Subject: Highways England initial response (our ref 89442 #11568) re. WA/68/20/OUT - Land West of Tye Lane, Walberton, BN18 0LU

For attention of:	Mrs A Gardner
Site:	Land west of Tye Lane, Walberton, BN18 0LU
Proposal:	Outline application with all matters reserved, other than means of access, for the construction of up to 155 No. dwellings (30% affordable homes) & amendment to boundary of garden land to serve adjoining property. This application affects the character & appearance of the Walberton Village Conservation Area, may affect

the setting of listed buildings & is a Departure from the Development Plan.
Your Reference:	WA/68/20/OUT
Highways England's Reference:	89442 #11568

Figure 5: PIA Data – Yapton Lane/A27 (Source: WSCC Safer Roads Partnership)

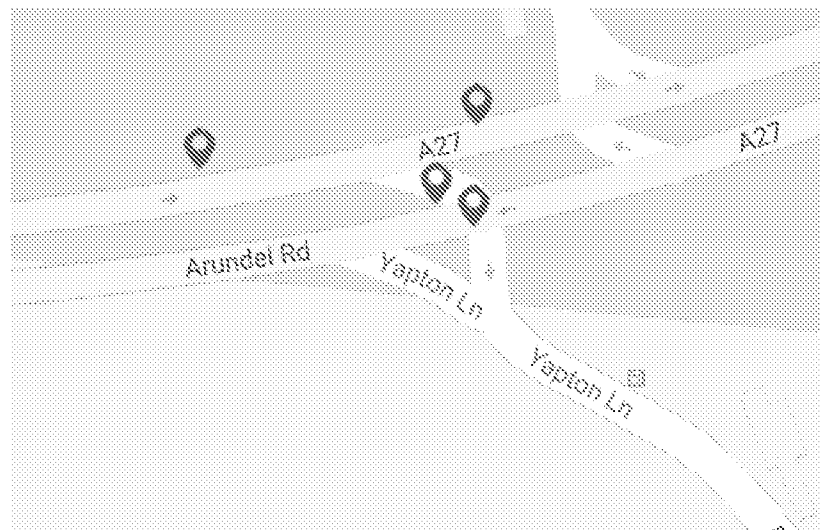
- *3. Existing Local Conditions*
 - Personal Injury Accident Data - please note that a full STATS19 accident analysis is required for the A27 junctions supported by the full data as this has not been provided.

Figure 8: PIA Data – A27/A29 Fontwell East Roundabout (Source: WSCC Safer Roads Partnership)

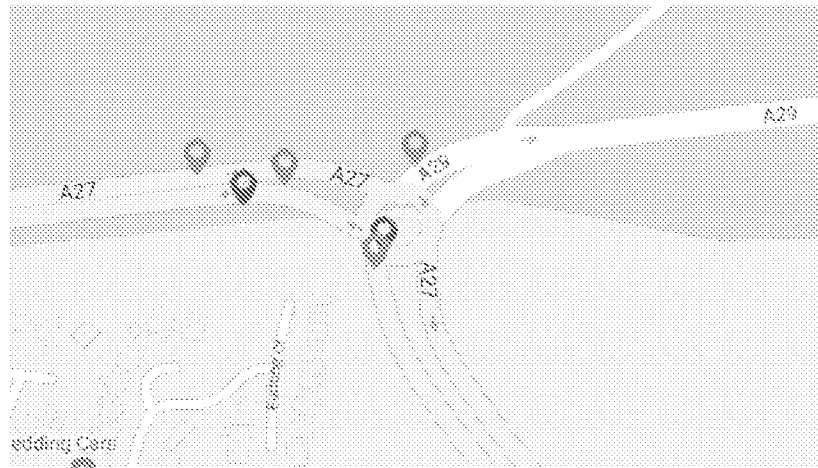
- Fontwell East Roundabout - please note that Highways England does not accept percentage impact assessments such as that undertaken in Table 19. This junction will need to be modelled to determine whether the junction still operates within capacity following the addition of the development's trips. If this is not the case, mitigation will need to be proposed to ensure that the junction operates within capacity.

Figure 9: PIA Data – A27/A29 Fontwell West Roundabout (Source: WSCC Safer Roads Partnership)

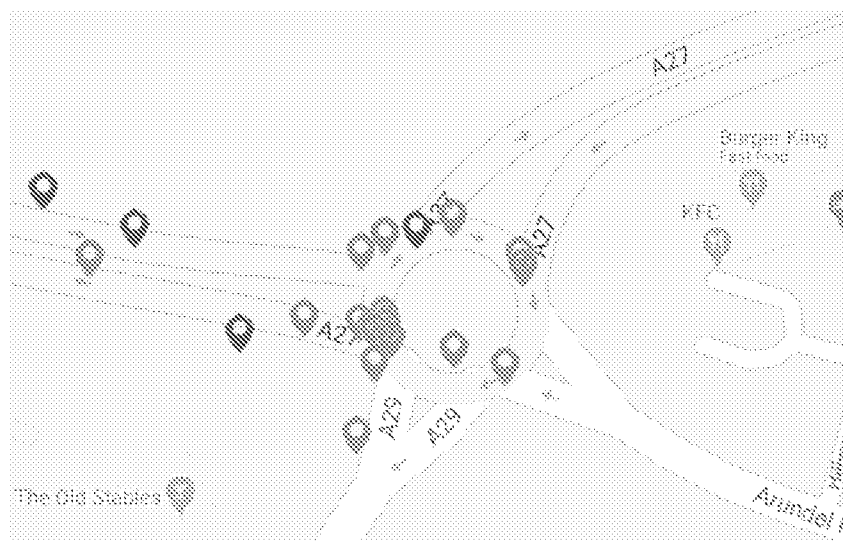
- Fontwell West Roundabout – please note that Highways England does not accept percentage impact assessments such as that undertaken in Table 18. This junction will need to be modelled to determine the mitigation required. As outlined, the 2031 scenario is predicted to operate overcapacity with the mitigation proposed by Land East of Tye Lane. As the development is adding additional trips to this junction, further mitigation should be considered to mitigate this impact to 'nil detriment'.
